From: Anita Gardner <Anita.Gardner@arun.gov.uk>
Sent: 25 February 2021 12:27
To: Planning.Responses <Planning.Responses@arun.gov.uk>
Subject: FW: LU/23/21/DOC

The agents have submitted a drainage report setting out their measures for foul and surface water disposal at the site but do not discuss measures required to divert sewer as required by condition which is being refused. But with regard to condition 8 in the response you do not comment on the measures proposed in paras 2.2 of the report.

Appendix C
Drainage Layout

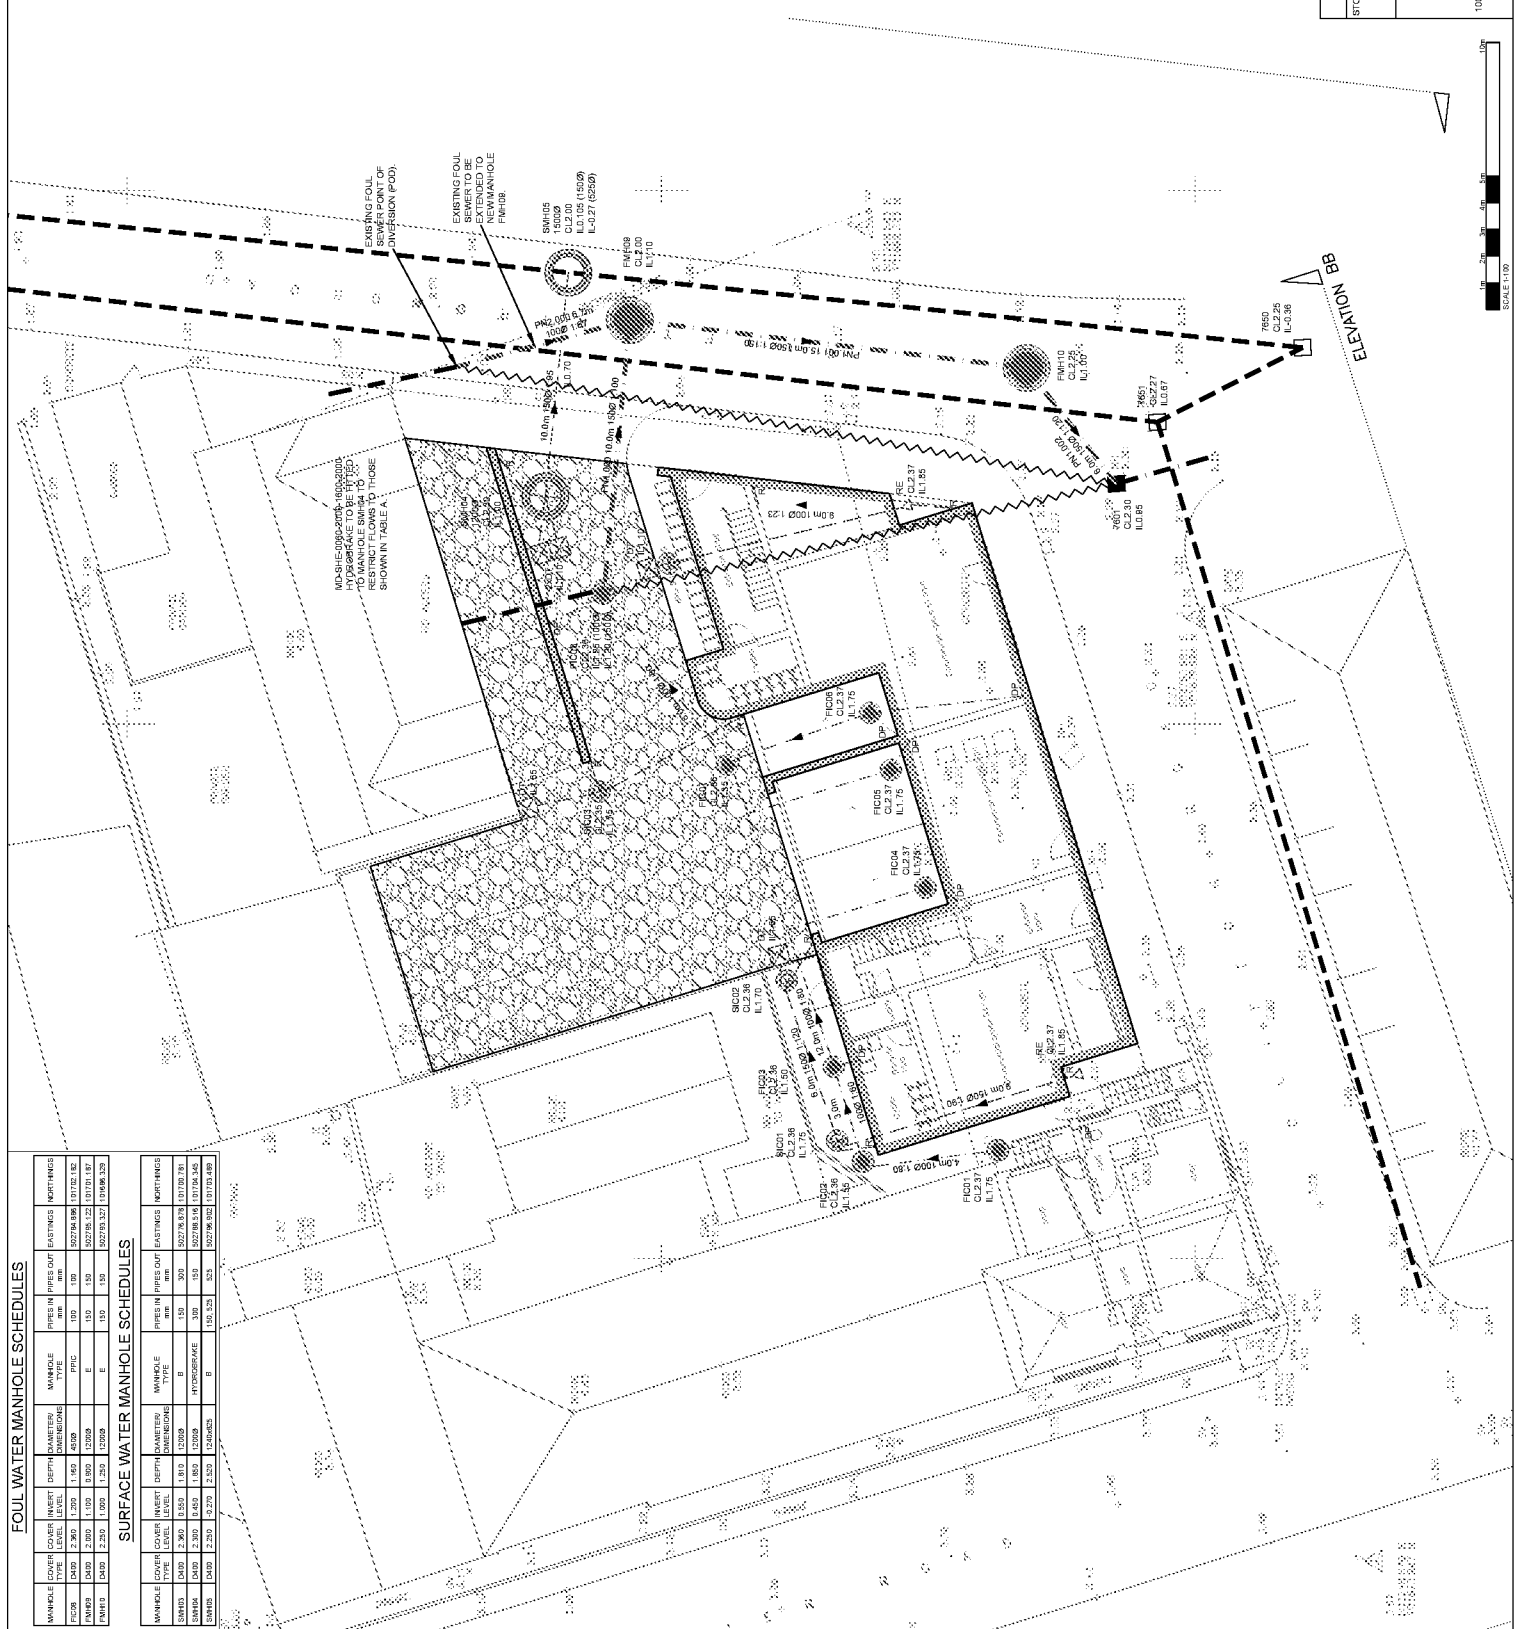
We do not discharge any conditions relating to foul and surface water until (if applicable) a S185 has been approved.

In this case the S185 has not yet been agreed so we are unable to discharge the condition.

Could you advise if you are in agreement with the measures?
